City of Albuquerque Stormwater Construction Site Inspection Report

ESC File No.	A11E017C	Project Name:	Tidal Wave Auto Spa
NPDES Id. No.	NMRI005J2	Location:	10601 Unser Blvd
6/14/2024	Owner	Contractor	
Operator	TWAS Properties LLC	Skarsgard Construction	
Contact name & title	Ryan Crumley	Jason Skarsgard	
e-mail	ryan.crumley@twavelead.com	jason@skarsco.com	
Contact Phone #	706-647-0414	505-262-2323	
COA Inspector	Chancellor English	Start/End Time:	12pm
Construction Phase:	Verticals		
Type of Inspection:	<input checked="" type="checkbox"/> Regular	<input type="checkbox"/> Storm Event	<input type="checkbox"/> Post Storm Event >0.25" <input type="checkbox"/> 311/Complaint <input type="checkbox"/> Follow Up
Weather at time of inspection?	Clear	Temperature: ~	95
Estimated date of last storm 0.25" or greater	6/10/2024

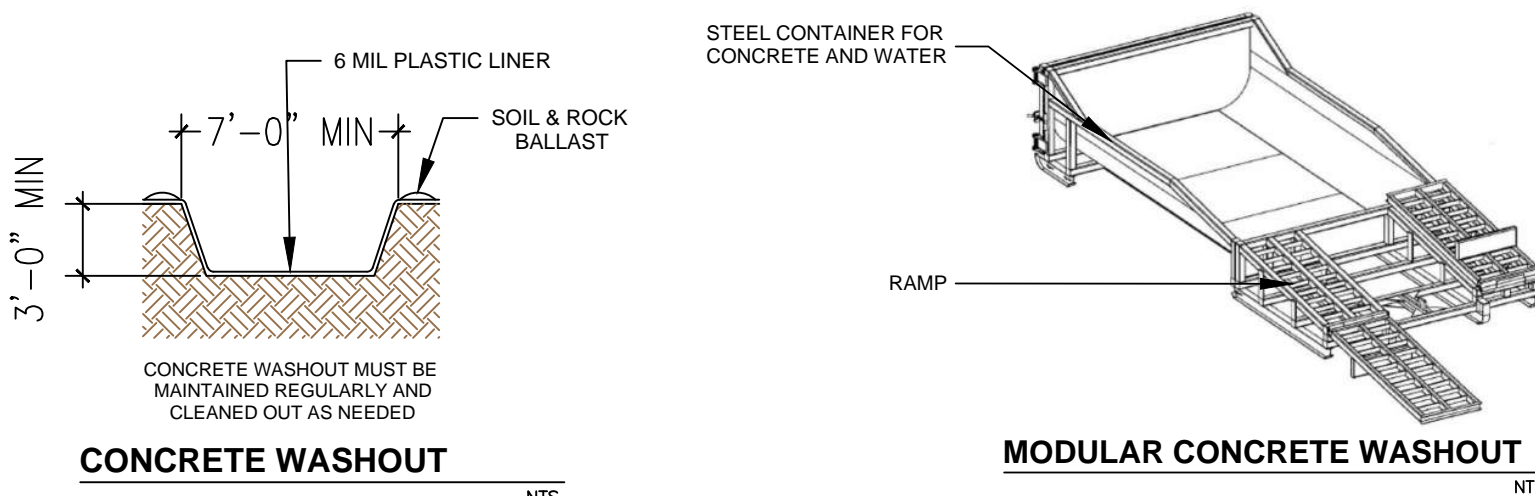
Item Number	Deficiency/ Corrective Action
1	The SWPPP Map is not current and does not show the parking and storage area across the access road in violation of CGP Part 7.4.1. The self-inspection reports were unavailable at the time of inspection in violation of CGP Part 4.7.3. Required mitigation: You must modify your SWPPP, including the site map(s), within seven days whenever you make changes to your construction plans, stormwater controls, or other activities at your site that are no longer accurately reflected in your SWPPP per CGP Part 7.4.1. You must keep a copy of all inspection reports at the site or at an easily accessible location so that it can be made immediately available at the time of an on-site inspection per CGP Part 4.7.3.
2	There is sediment along the access road in between the active construction site and the parking/storage area caused by track-out in violation of CGP Part 2.2.4. Required mitigation: Where sediment has been tracked-out from your site onto paved roads, sidewalks, or other paved areas outside of your site, remove the deposited sediment by the end of the same business day in which the track-out occurs. Remove the track-out by sweeping, shoveling, or vacuuming these surfaces per CGP Part 2.2.4.

Notes:	Mr. Crumley is not reachable by phone.
Construction entrance for parking/storage area is full of sediment and needs repair/maintenance to reduce track-out. The SWPPP contact information on the posting is incorrect and should be updated. Sediment removal and inlet protection is suggested for the clogged storm drain on the southwest side of the construction site.
